# CITY OF ALBUQUERQUE

Site: Montecito Vistas

**Re: Drainage Ordinance (14-5-2-1) Violations for Erosion and Sediment Control**

CITY OF ALBUQUERQUE PUBLIC WORKS DEPARTMENT	
MONTECITO VISTAS EROSION CONTROL PLAN			
Design Review Committee	City Engineer Approval	Mo./Day/Yr.	Mo./Day/Yr.
City Project No. 763983		Sheet 1 Of 2	
		Zone Map No. D-09	
		City Project No. 763983	
		Zone Map No. D-09

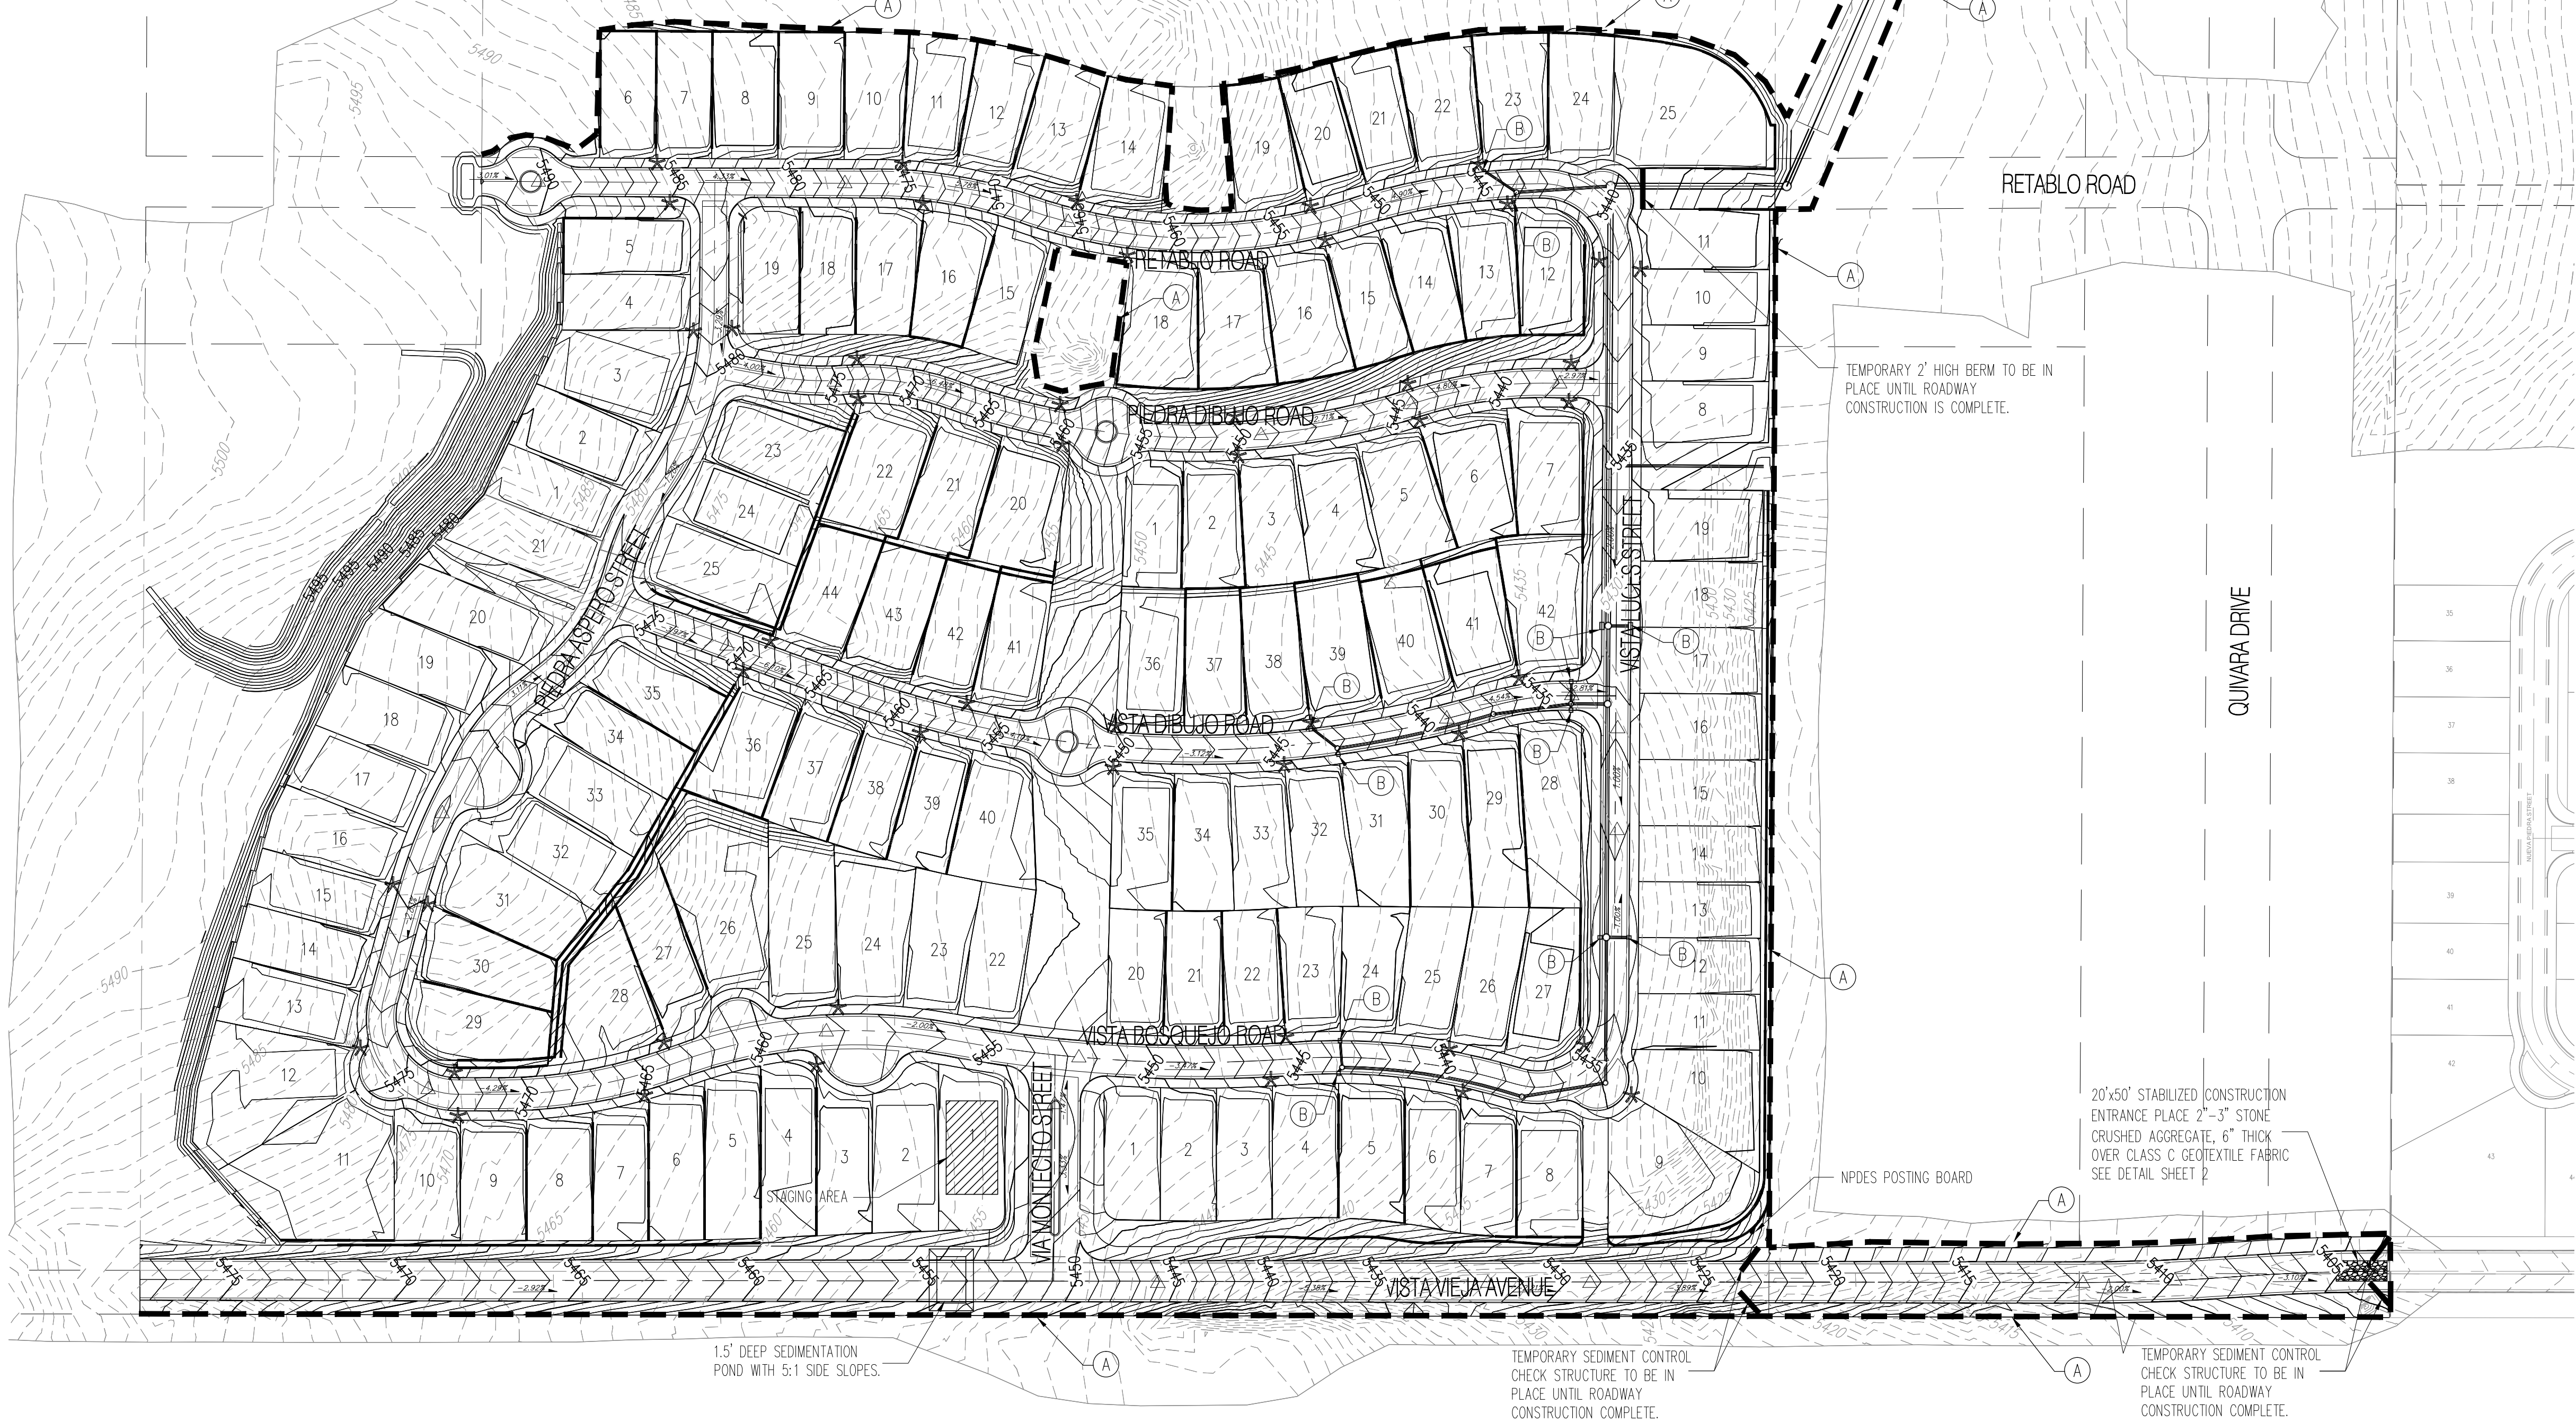
1. There is no erosion protection at the end of the storm drain that drains the subdivision. This is causing erosion and sediment deposition in the arroyo.
2. No track-out pad where water trucks enter Vista Vieja Ave. Sediment in road.
3. No track-out pad at interface from west dirt area onto Vista Vieja Ave. Sediment in road.
4. There is no erosion or sediment BMP to prevent sediment in west area from entering Vista Vieja Ave.
5. No sediment BMP at west end of graded road in approximate location of Retablo Rd.
6. In numerous locations, there was sediment in the gutter pan that drained to an inlet without inlet protection. One location also had trash.

1. Install erosion protection at the end of the storm drain that drains the subdivision per the approved construction plans (CPN 763983).
2. Install a track-out pad where water trucks enter Vista Vieja Ave. Remove sediment from street and gutter pan.
3. Install a track-out pad at interface from west dirt area onto Vista Vieja Ave. Remove sediment from street and gutter pan.
4. Provide a BMP to prevent sediment from west area from entering Vista Vieja Ave. A berm to direct flows to a pond may be an appropriate BMP.
5. Install a sediment BMP at the west end of the graded road in approximate location of Retablo Rd.
6. Provide inlet protection (rock bag OK) in gutter upstream of inlets in numerous locations. Remove sediment piles, dirt ramp and trash from gutter pan.
